Re: Settlers View Subdivision
My Job Number: 16-025
Your P-17-004 & SP-17-006

January 09, 2018

This letter will respond to your Rezoning comment letter dated August 04, 2017 and your Preliminary Plan comment letter dated August 14, 2017.

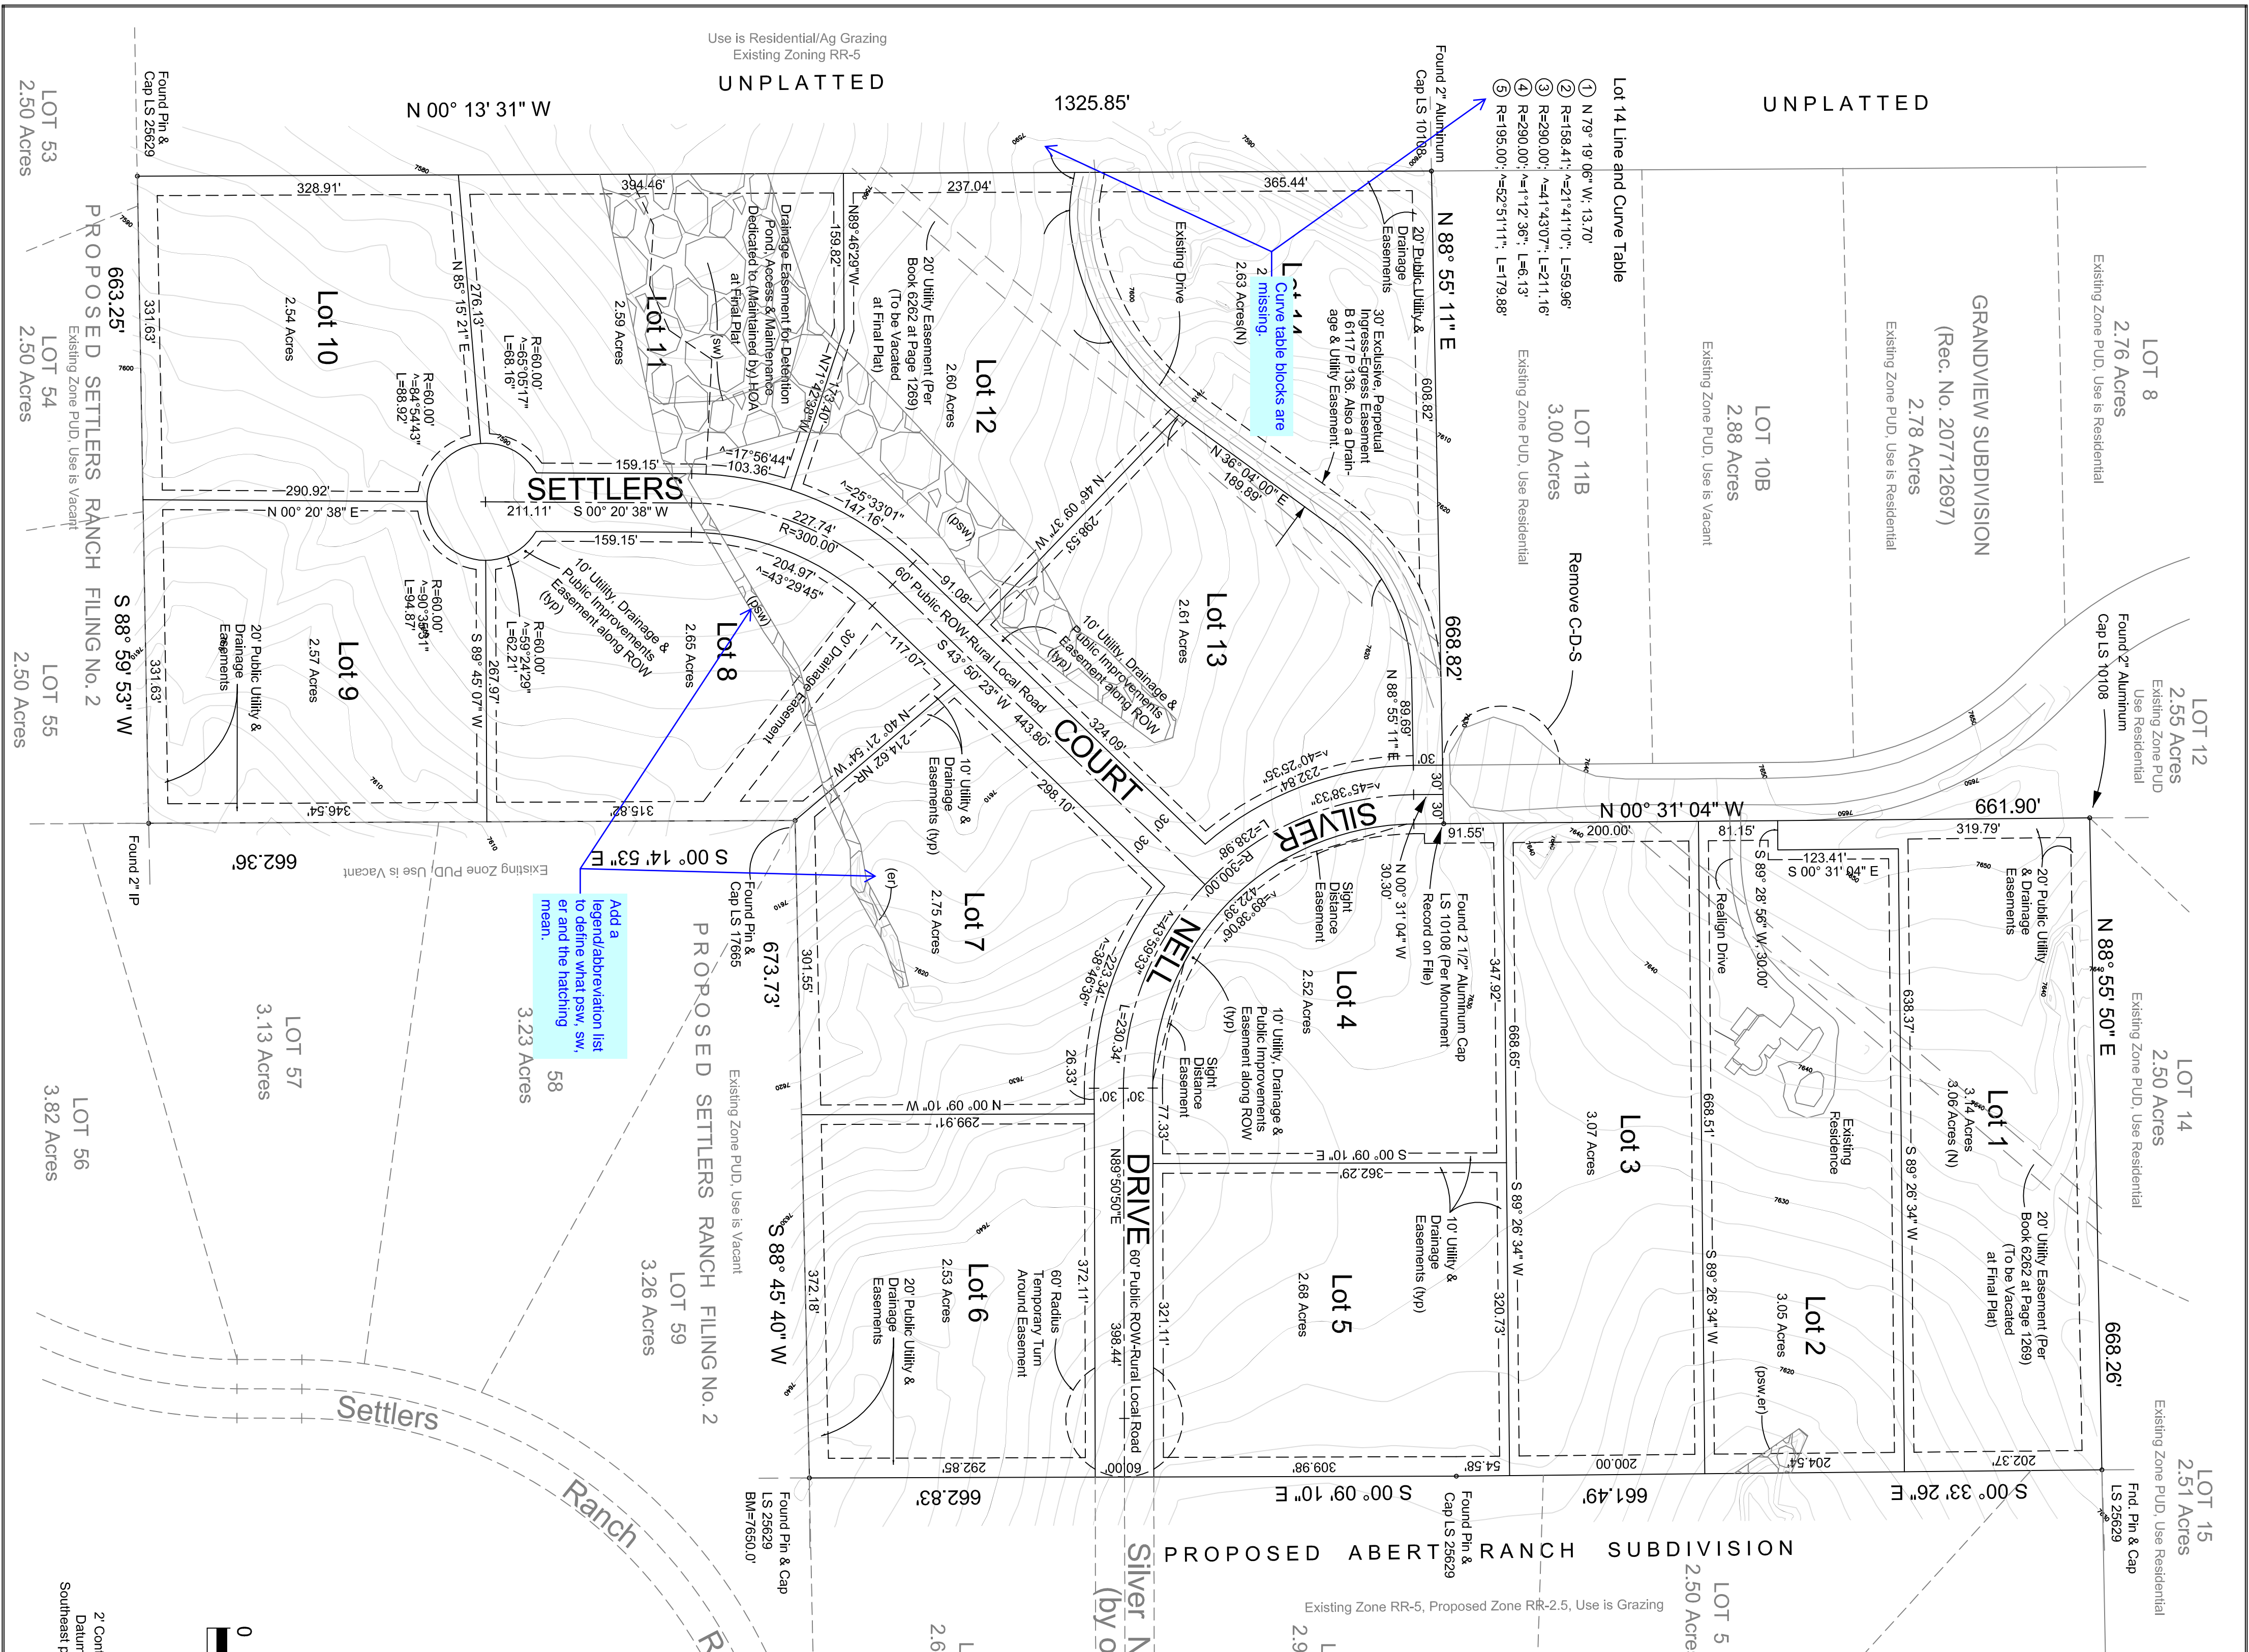
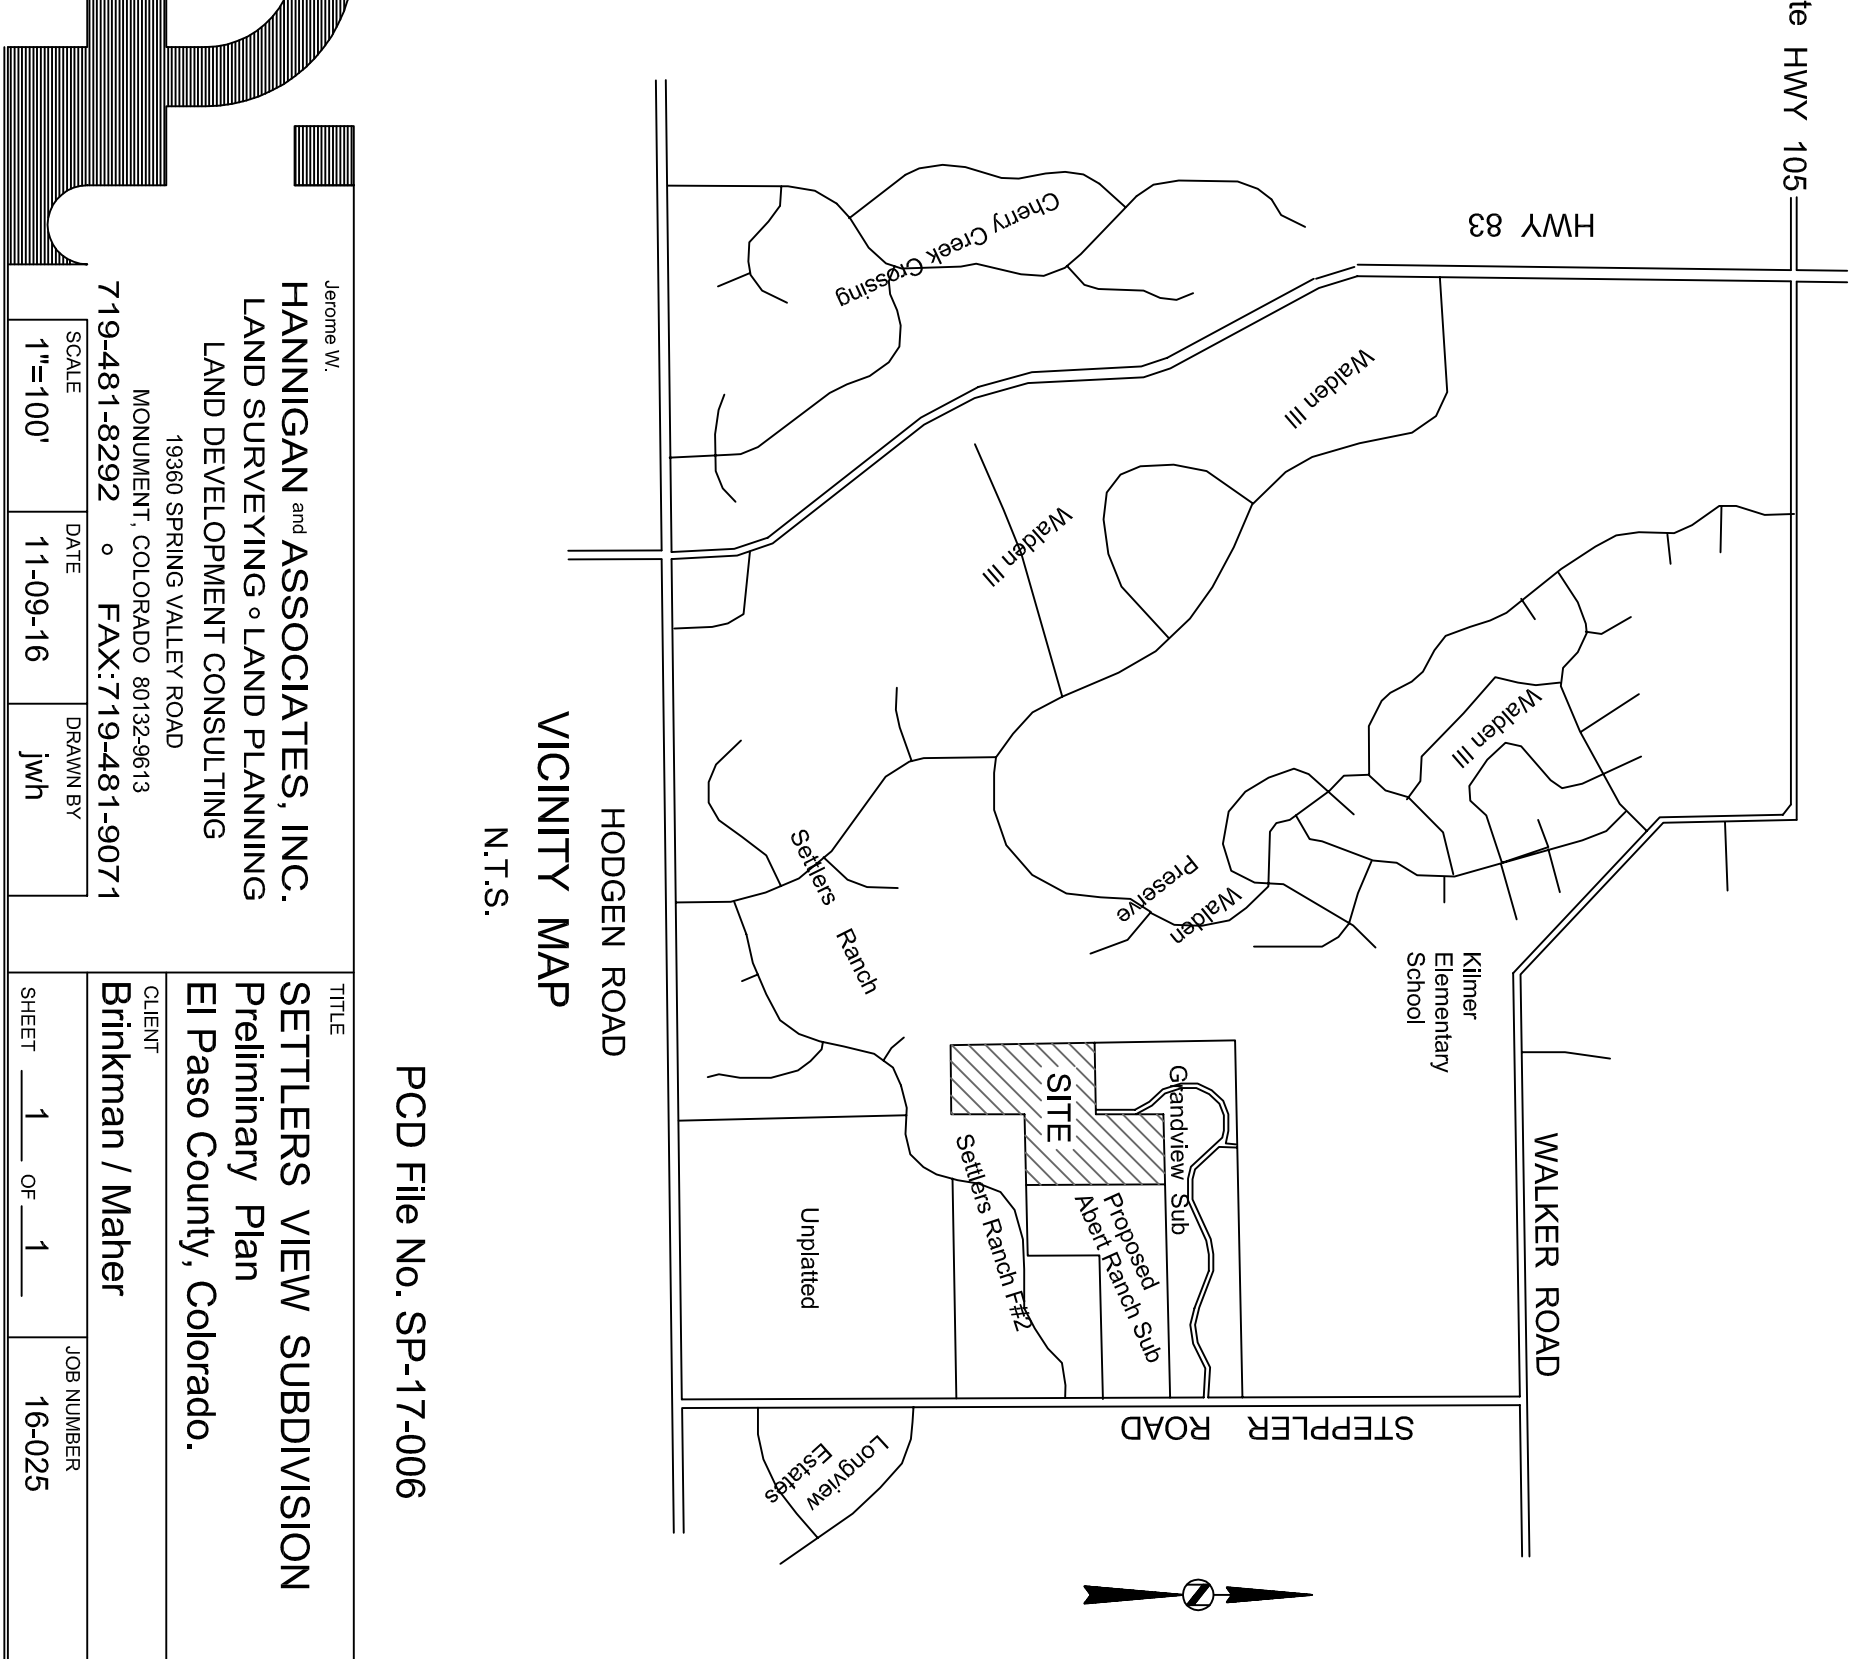
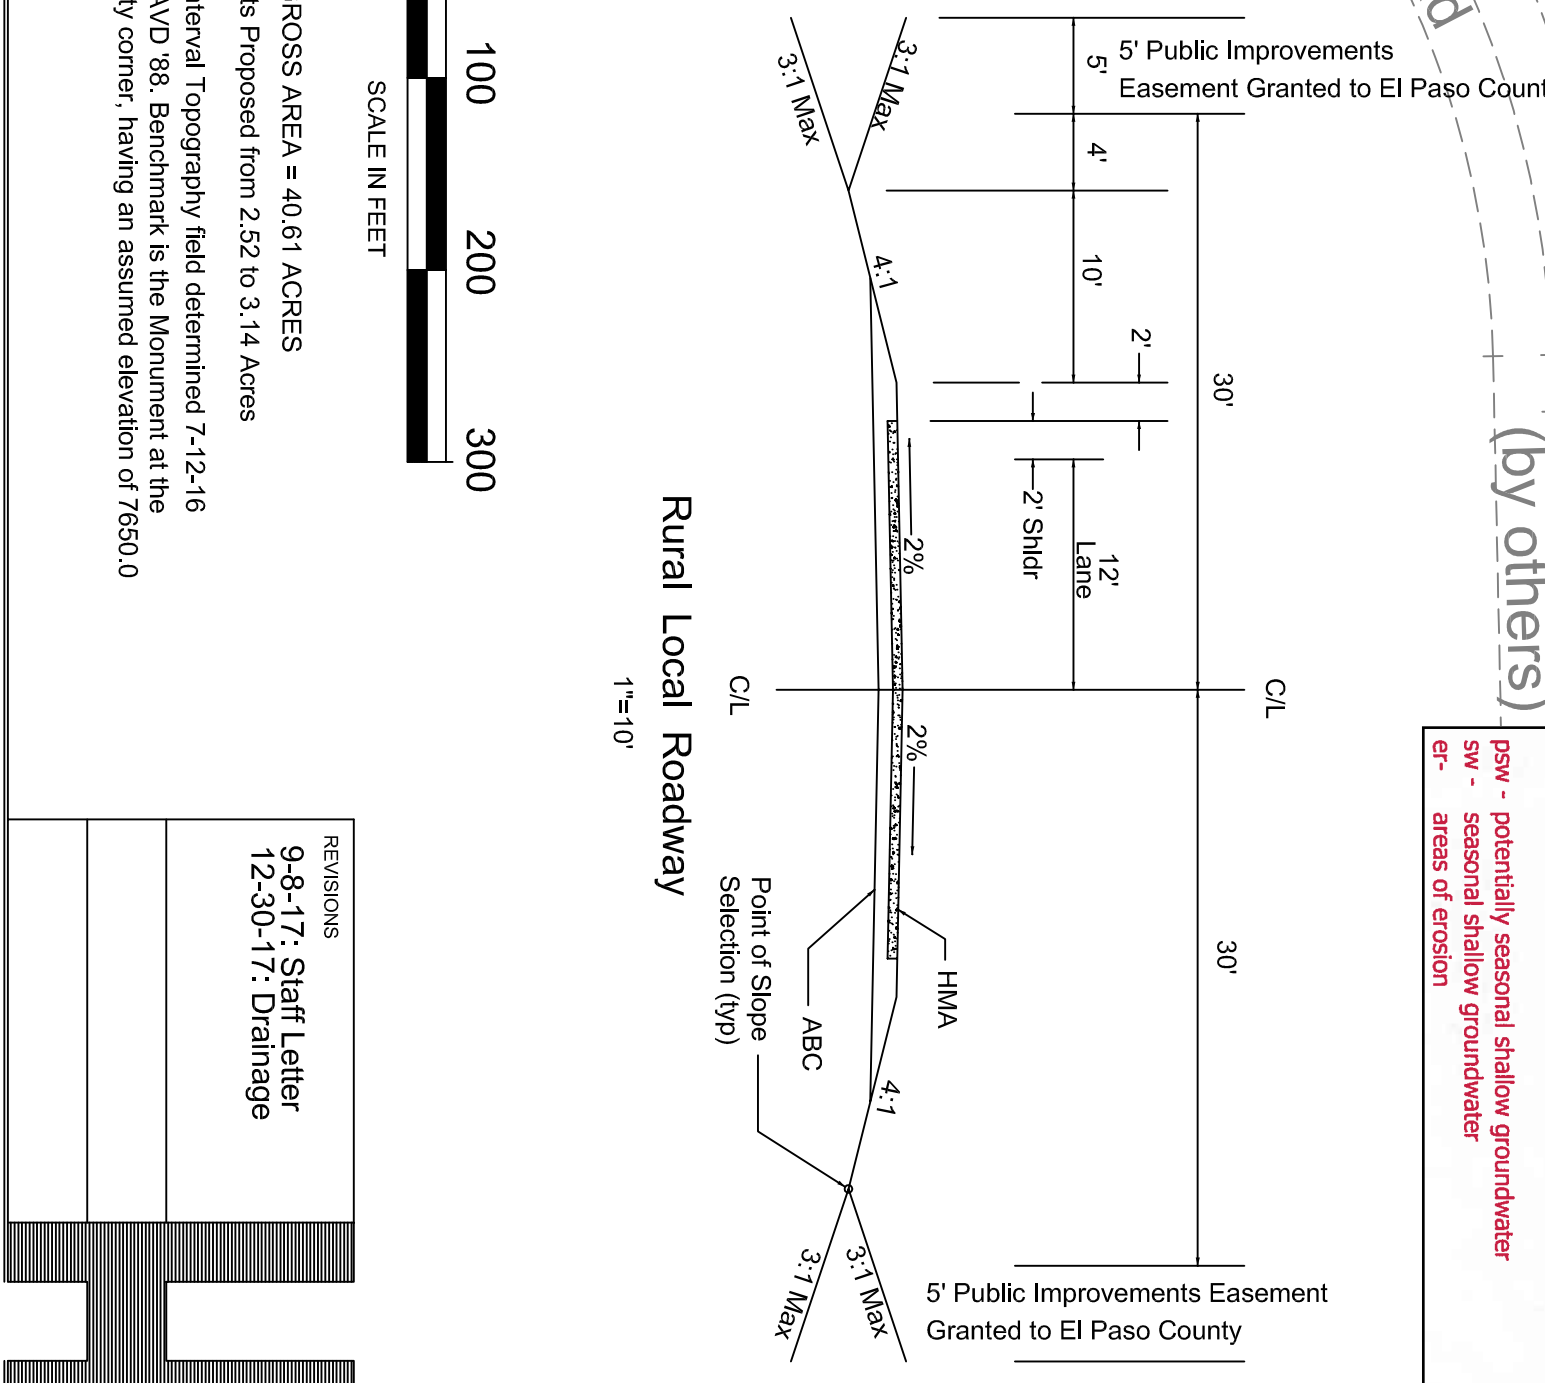
3.) Geologic Hazards are shown on the plan.

4.) No septic suitability map was provided relating to high groundwater. Hazard possibility exists though, and is noted on the plan.
